Reference: 260662.01FA

**REVIEW OF TRAFFIC AND PARKING IMPACTS OF THE PROPOSED
 SENIORS HOUSING DEVELOPMENT AT
 19-25 COLLEGE CRESCENT & 9-15 LINK ROAD, ST IVES**

Reference is made to your request to provide a review of the traffic and parking impacts of the proposed Seniors Housing Development at 19-25 College Crescent & 9-15 Link Road, St Ives under application SSD-98363228. This letter provides a peer review of the EIS documentation relating to traffic and parking and an assessment of the impacts on College Crescent based on the information available.

Figure 4 Ground Floor Site Plan

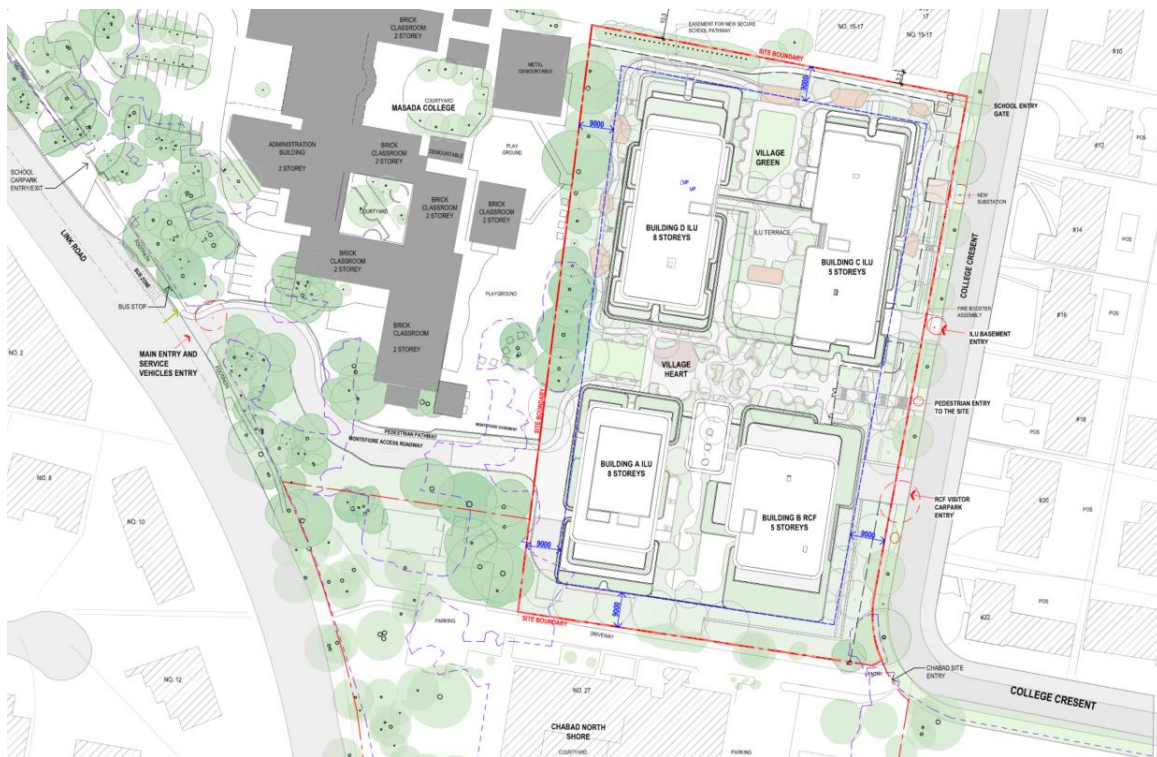
As shown, the UTIA fails to quantify the number of parking spaces that will be removed from the school as a result of the development. Since the removal of the school's on-site parking spaces will have direct impacts on the surrounding on-street parking network, deferring resolution of the parking shortfall to a future and uncertain Masada College Site Masterplan is inadequate.

As shown above, the proposed development will result in a loss of at least **18** car parking spaces at Masada College. Additionally, as part of the proposal, six (**6**) on-street parking spaces along the western side of College Crescent will be removed due to the introduction of 'No Stopping' zones.

Therefore, a total of **24** car parking spaces will be removed as a result of the proposal. However, the UTIA fails to assess the impact of the removal of car parking spaces on the surrounding on-street parking network. The application should assess how equivalent parking capacity will be provided or otherwise appropriately mitigated prior to determination.
